**From:** FRS Water and Access [REDACTED]  
**Sent:** 11 February 2025 15:45  
**To:** Planning.Responses <Planning.Responses@arun.gov.uk>  
**Subject:** Hydrant condition - FG/15/25/PL Kivesborough Littlehampton Road Ferring BN12 6PN

### **HYDRANT CONDITION CONSULTATION WITH PLANNING AUTHORITY**

Project		
Kivesborough		
Fire Appliance SPA OUT		
Drawn	Date:	Scale (at A3)
BTM	17/10/2023	1:200
Dwg no.	Revision No.	
KB/SR/5004	A

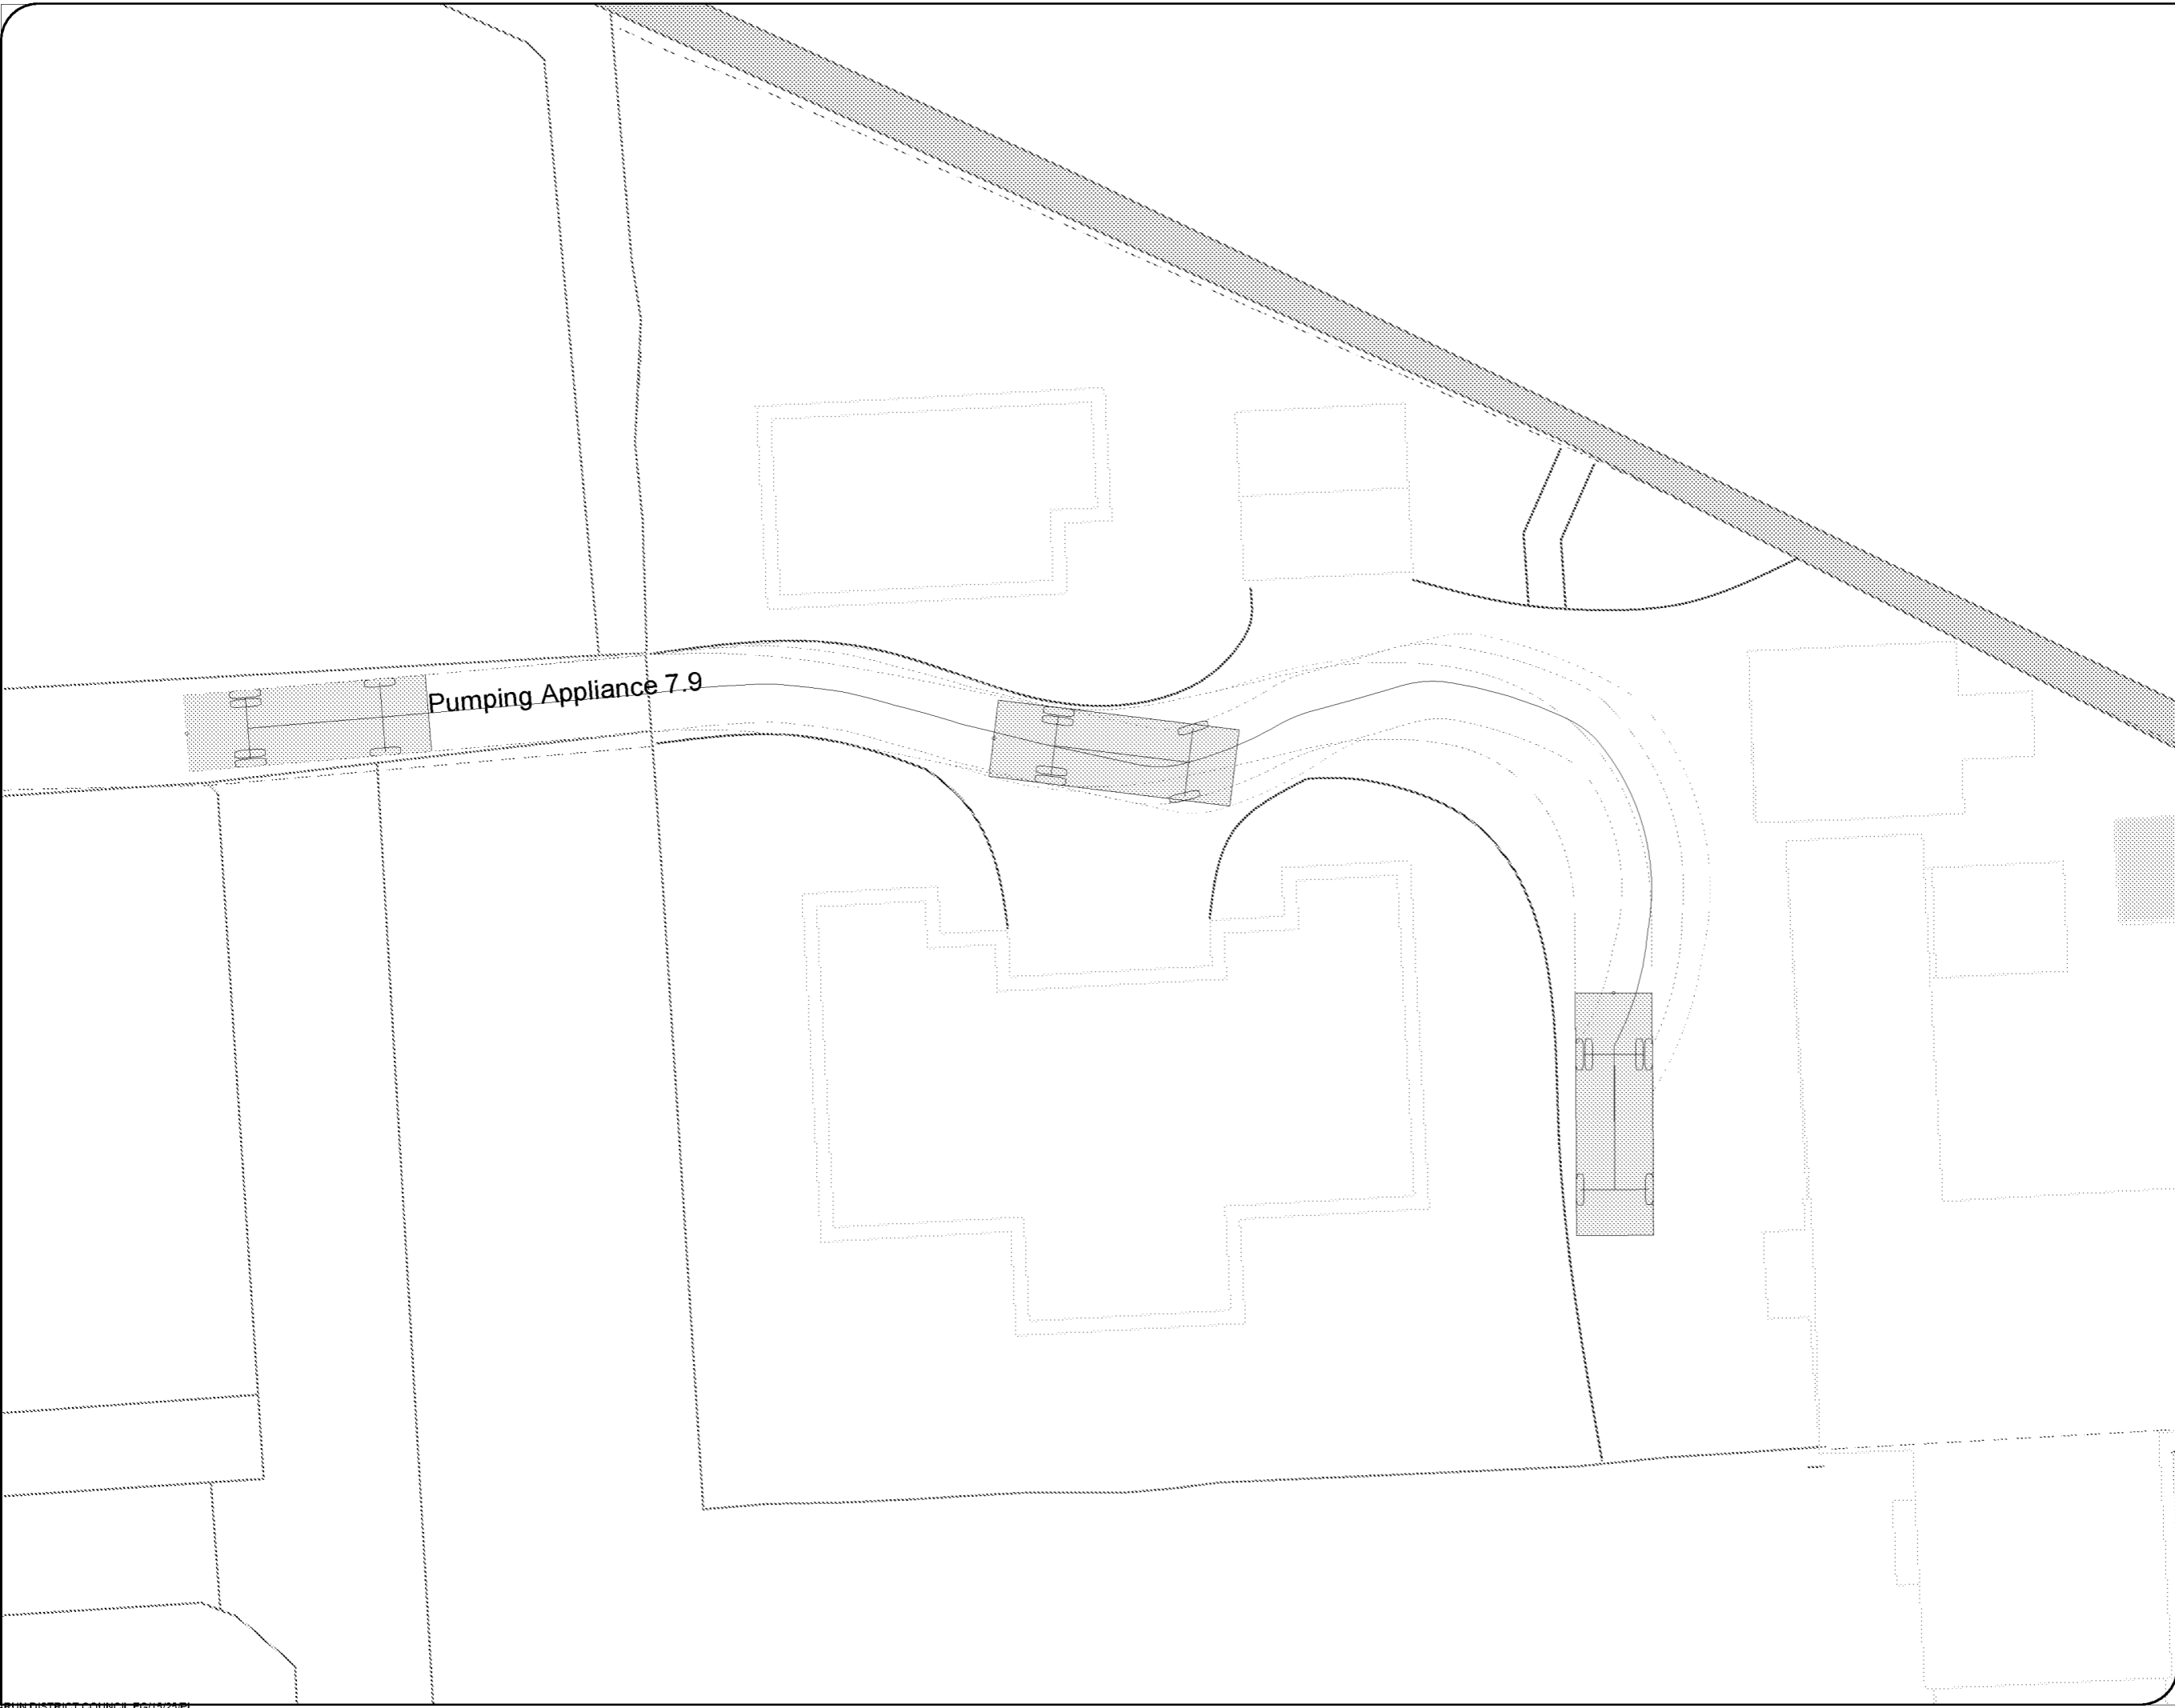
Evidence will also be required that Fire Service vehicle access meets with the requirements identified in Approved Document B Volume 1 2019 Edition: B5 Section 13, including Table 13.1 and diagram 13.1.
